Please ask for: Mrs D Johnson
Email: daun.johnson@arun.gov.uk
Telephone: 01903 737762
Our Ref: BR/175/20/PL
Your Ref:
Date: 6th August 2020

Application for Planning Permission

Development: Change of use from Student Accommodation to 3 no. dwellings, comprising 1 no. one bed apartment, 1 no. two bedroom house and 1 no. three bedroom house (resubmission of application BR/99/20/PL).
Location: 23 Mead Lane Bognor Regis PO22 8AP

SOUTHERN ELEVATION

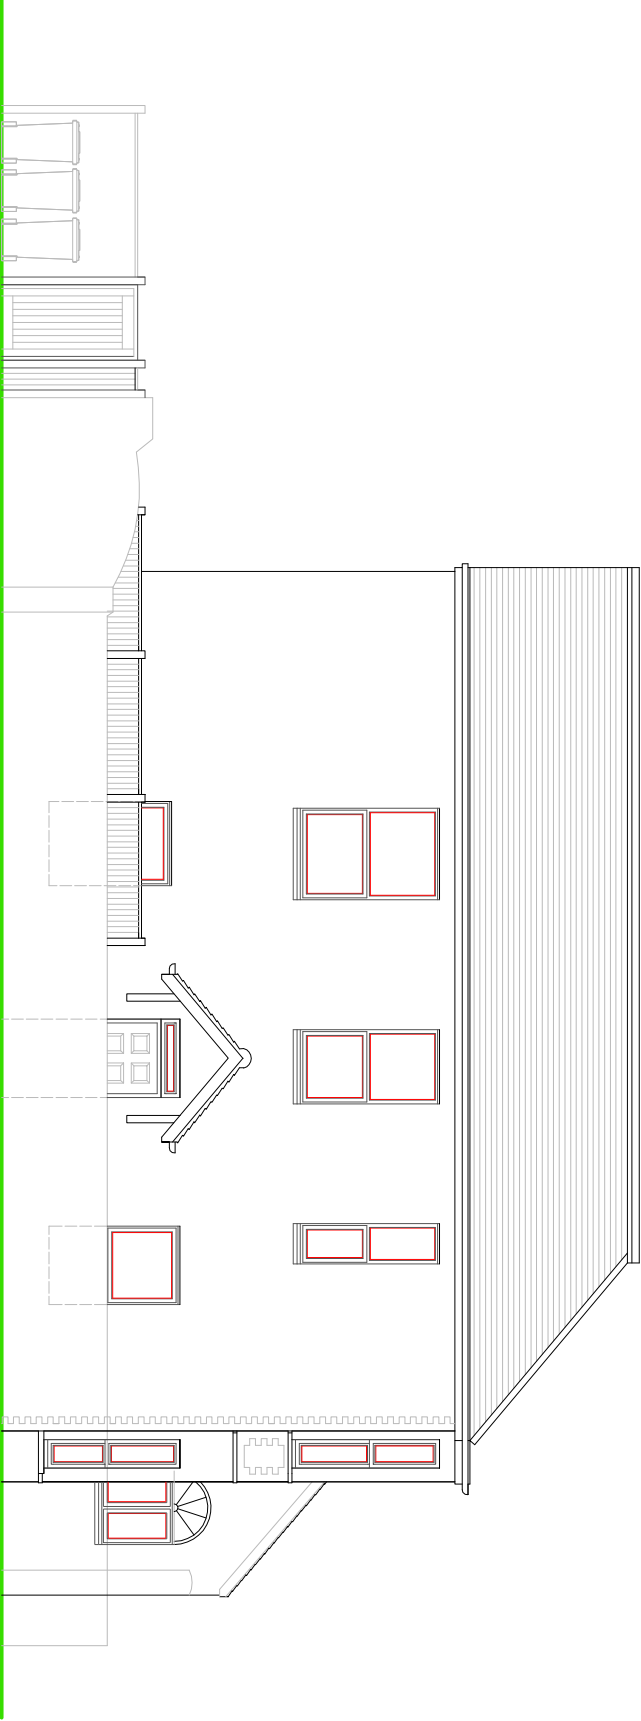
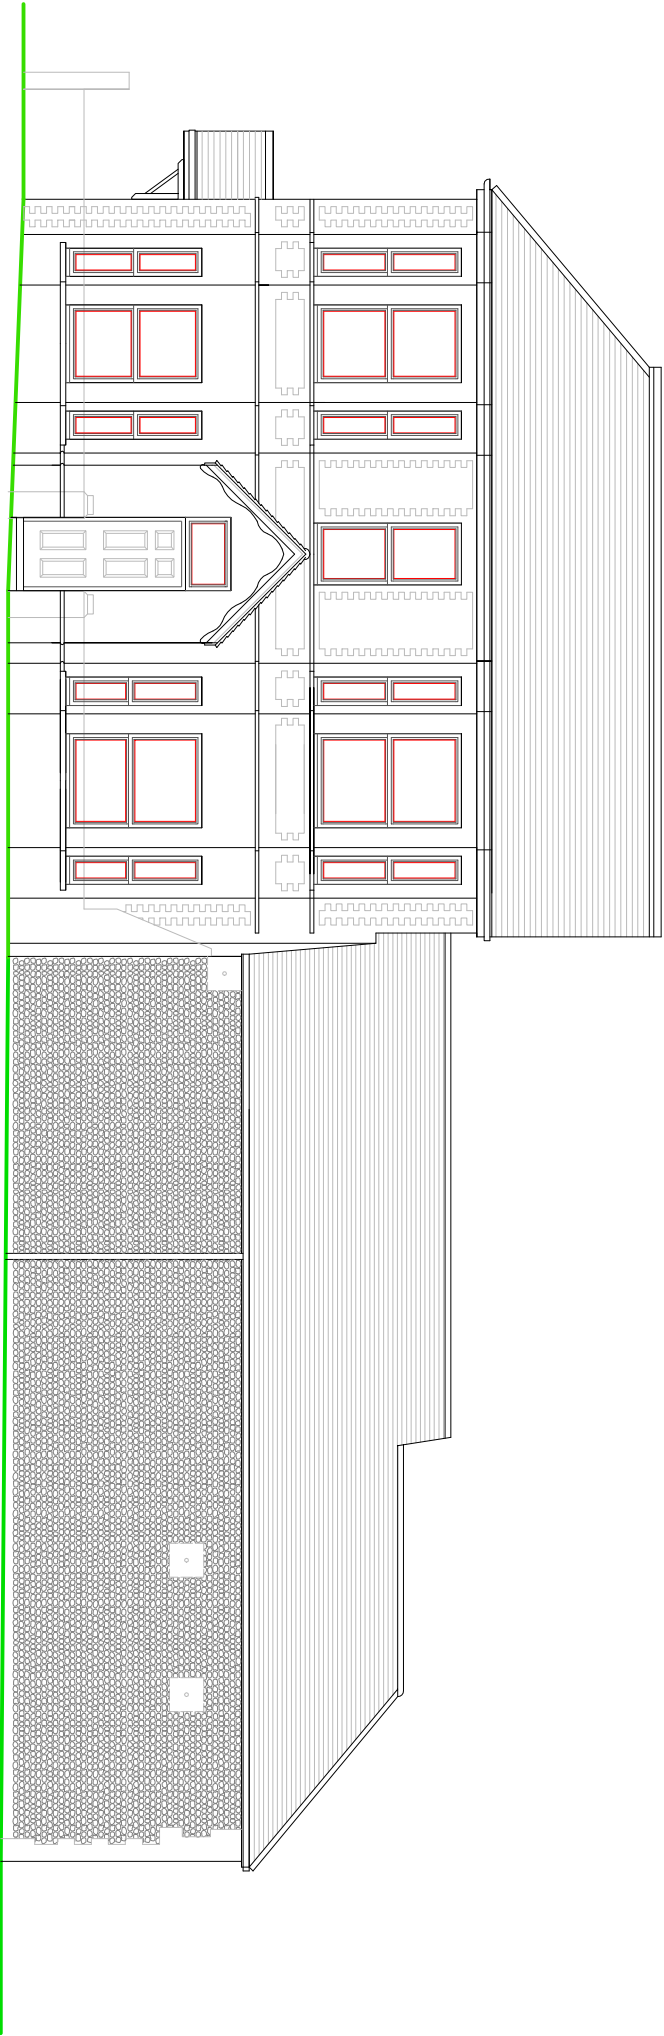
Please label the proposed south elevation.
